Appeal Decision

Appeal Ref: APP/R5510/W/21/3288792

40A Windmill Hill, Ruislip HA4 8PX

Drawing Title
EXISTING AND PROPOSED SIDE
ELEVATIONS AND SECTIONS 1
Drawn/Design
Date 01/05/21
Scales: Drawing No Rev
AS SHOWN @ A1 PL-105 B
10/12/2021 07:41:27

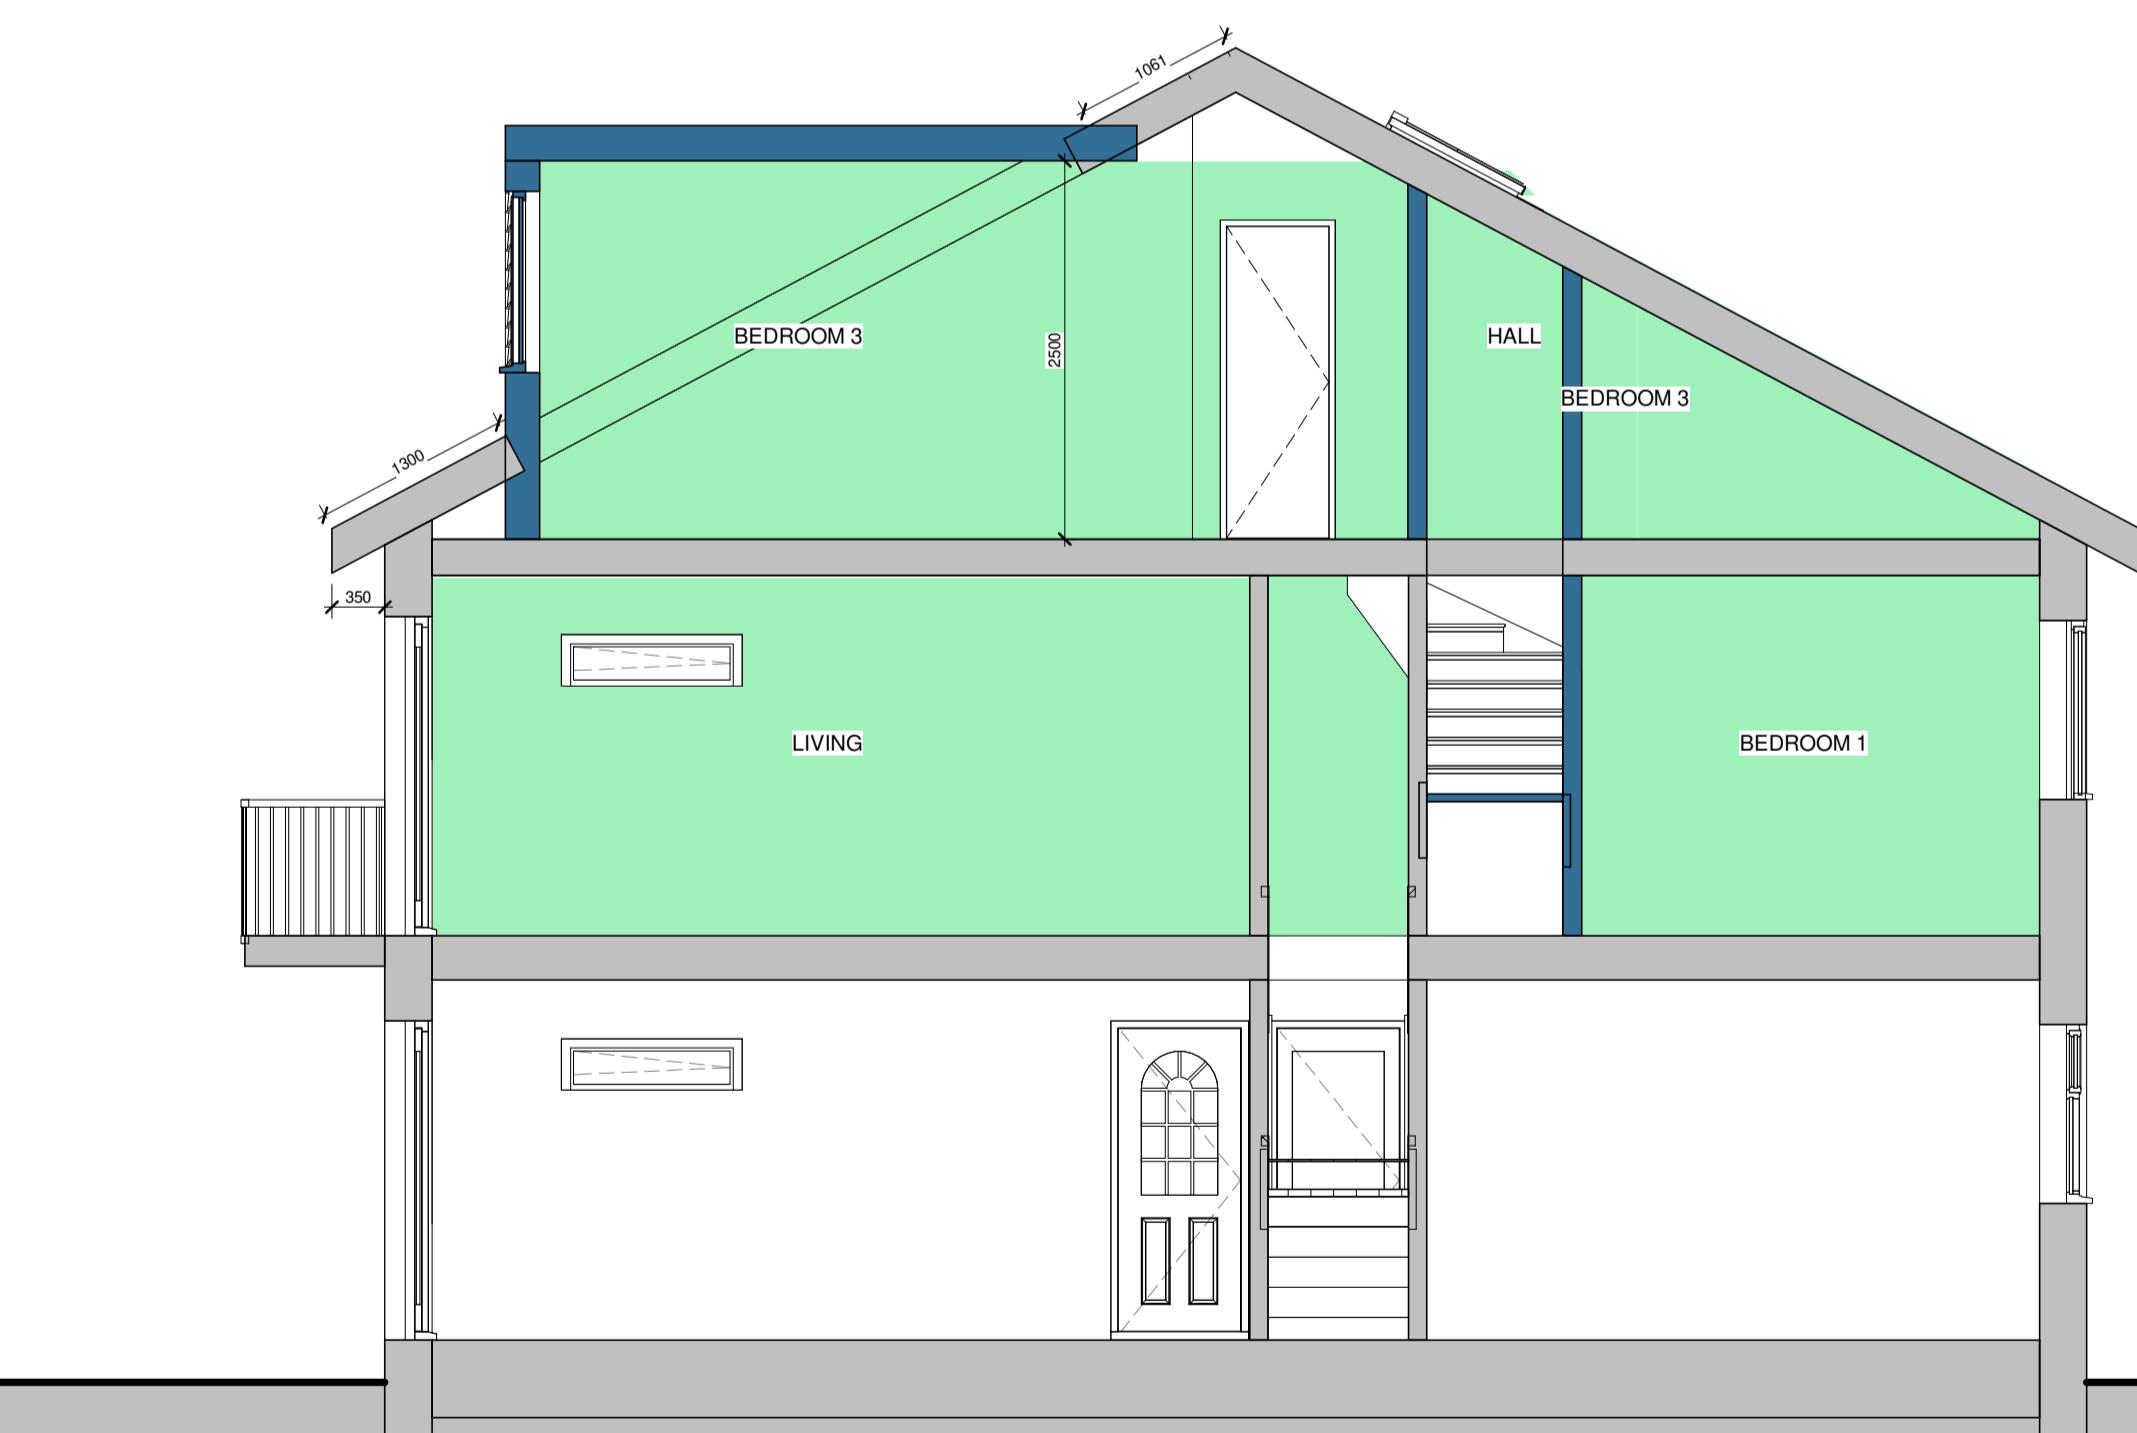
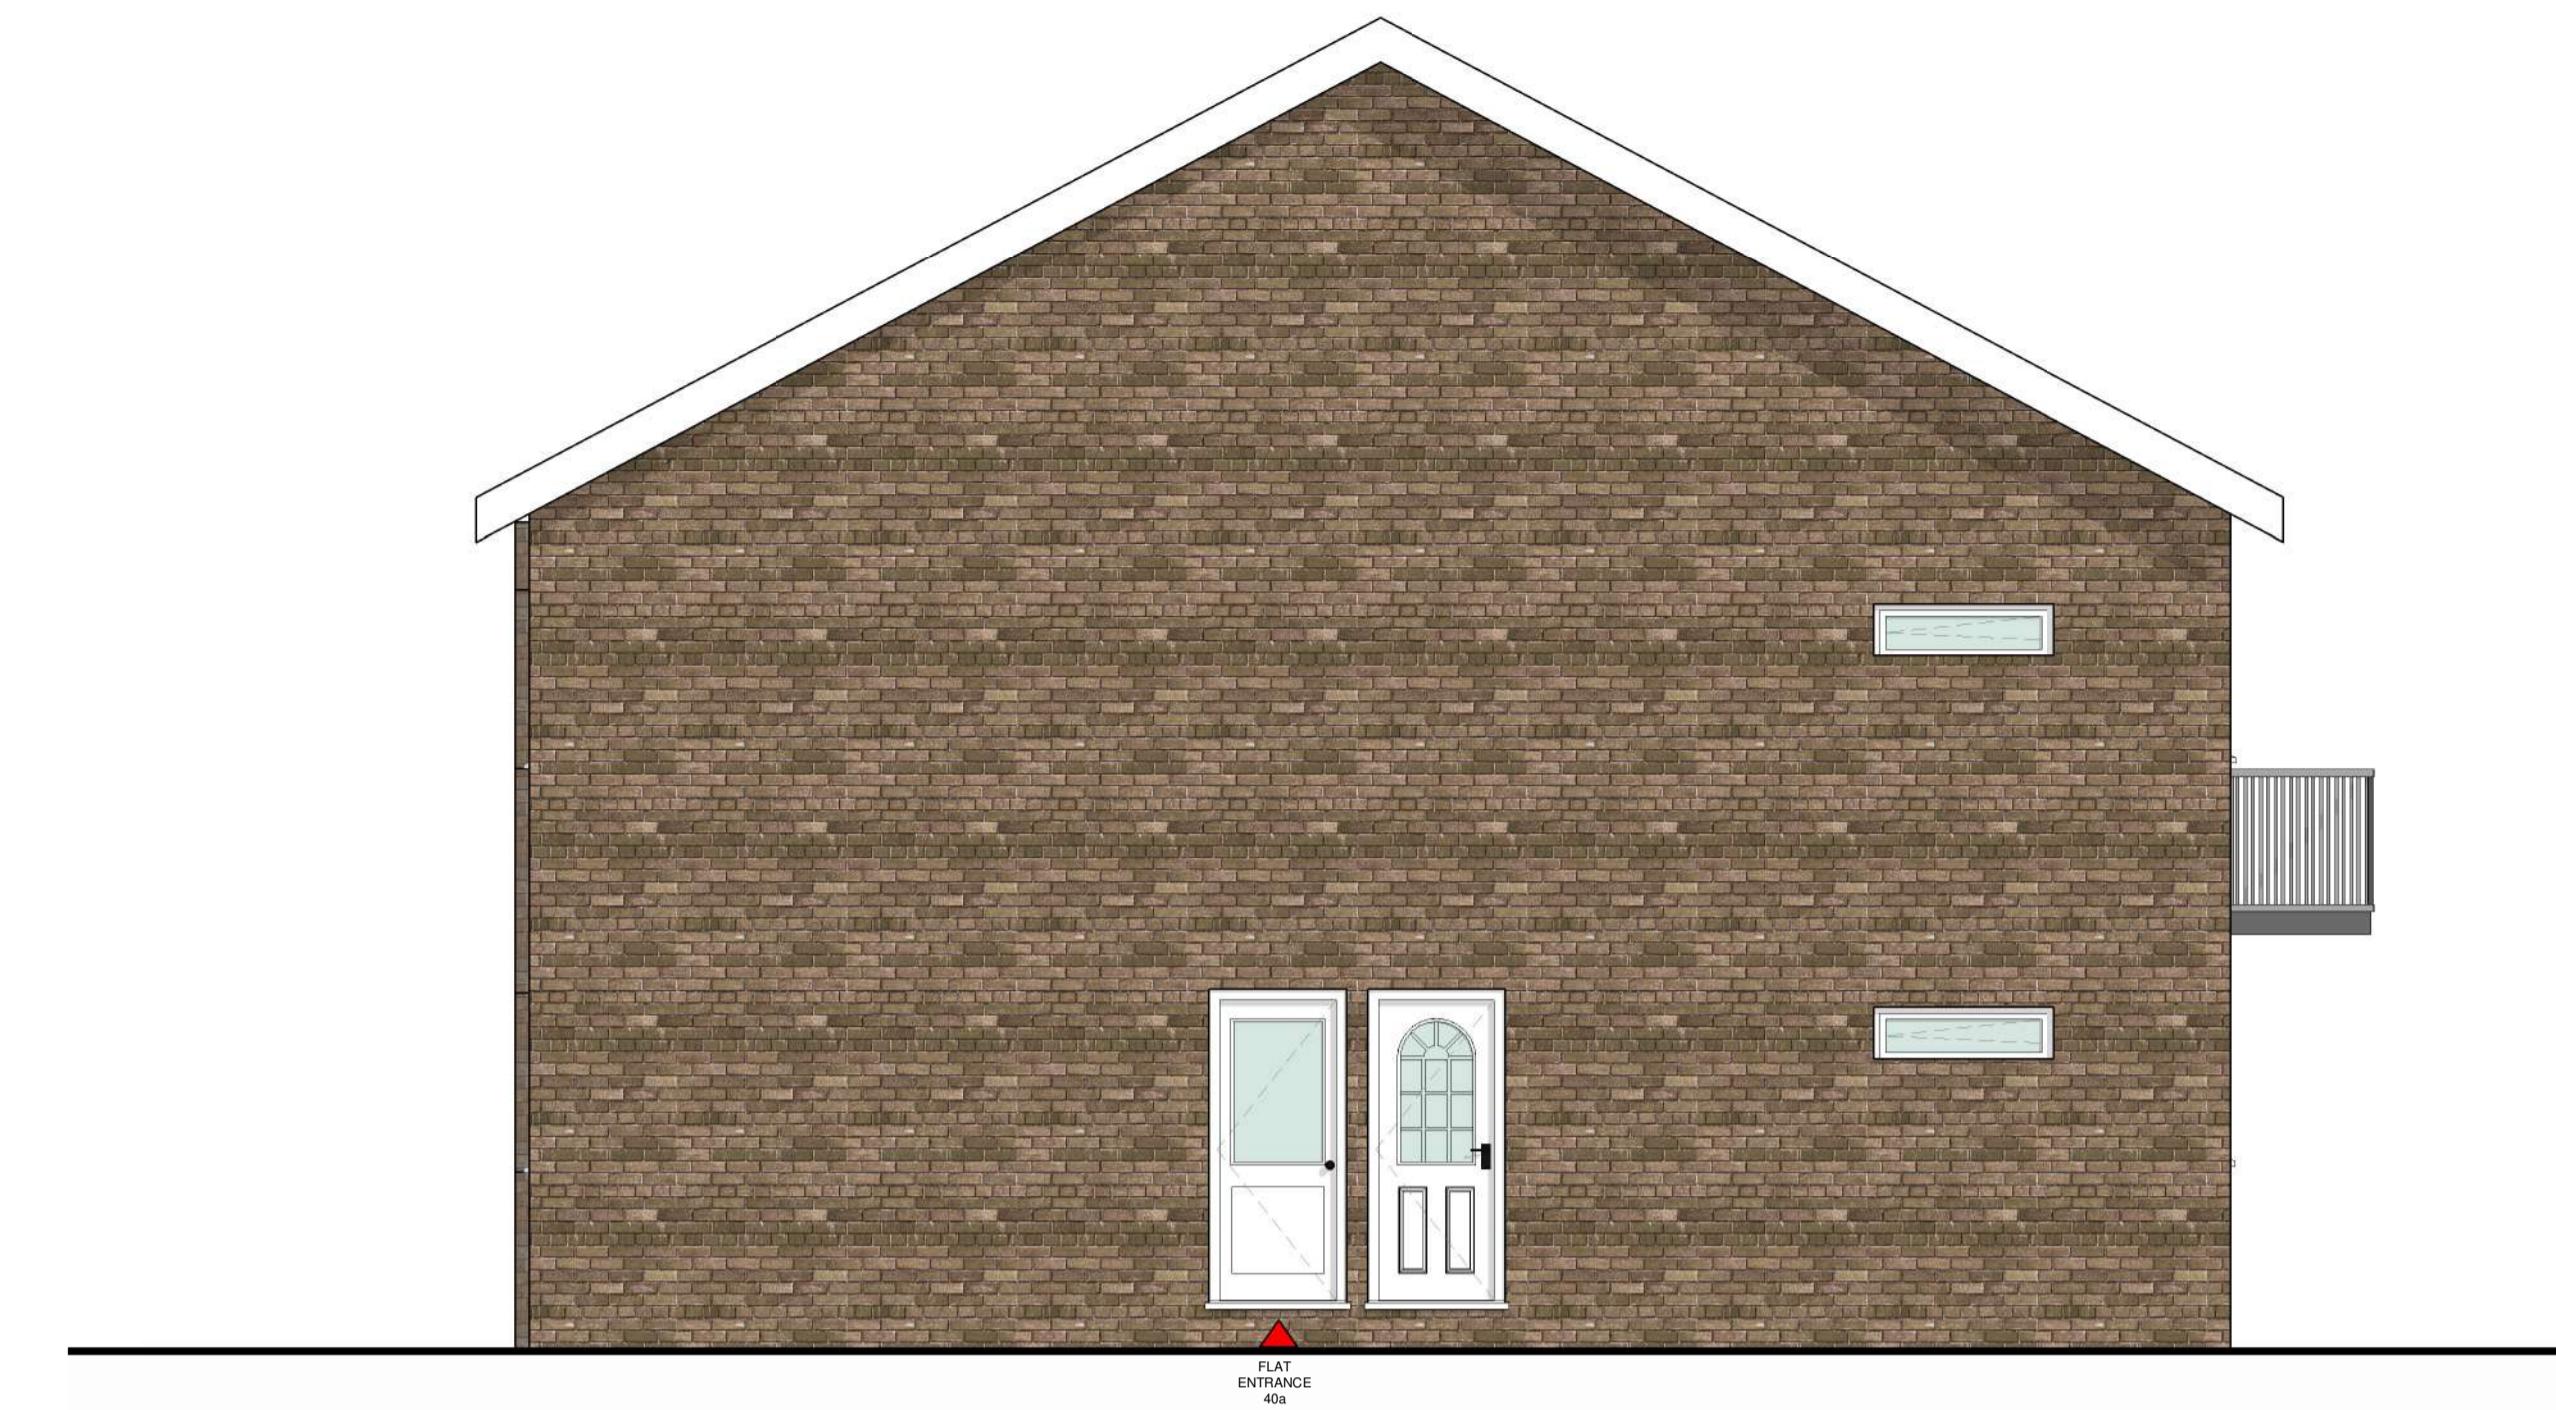
7. In this context, the proposed dormer window would be a substantial and dominant feature within the rear roof slope. Whilst located below existing ridge tiles it would fail to retain a substantial element of the original roof slope of the appeal property and would be neither subservient to the scale of the existing roof of the appeal property, nor to the building as a whole. It would, thus, be an incongruous 'over-large' extension that would fail to respect the otherwise modest proportions and simple design of the existing building or harmonise with surrounding local context.

9. Rather, it is the scale and slab-fronted / sided proportions of the proposed dormer together with its limited insets and set-downs that ensure it would be a disruptive and intrusive roof alteration on an otherwise modestly plan and architecturally simple building. As a consequence the proposed dormer window extension would be excessively scaled and overly large within the context of the appeal property and existing building and would dominate the rear roof slope and rear elevation of the building. Nor would it be truly subservient to the scale of the existing roof slope.
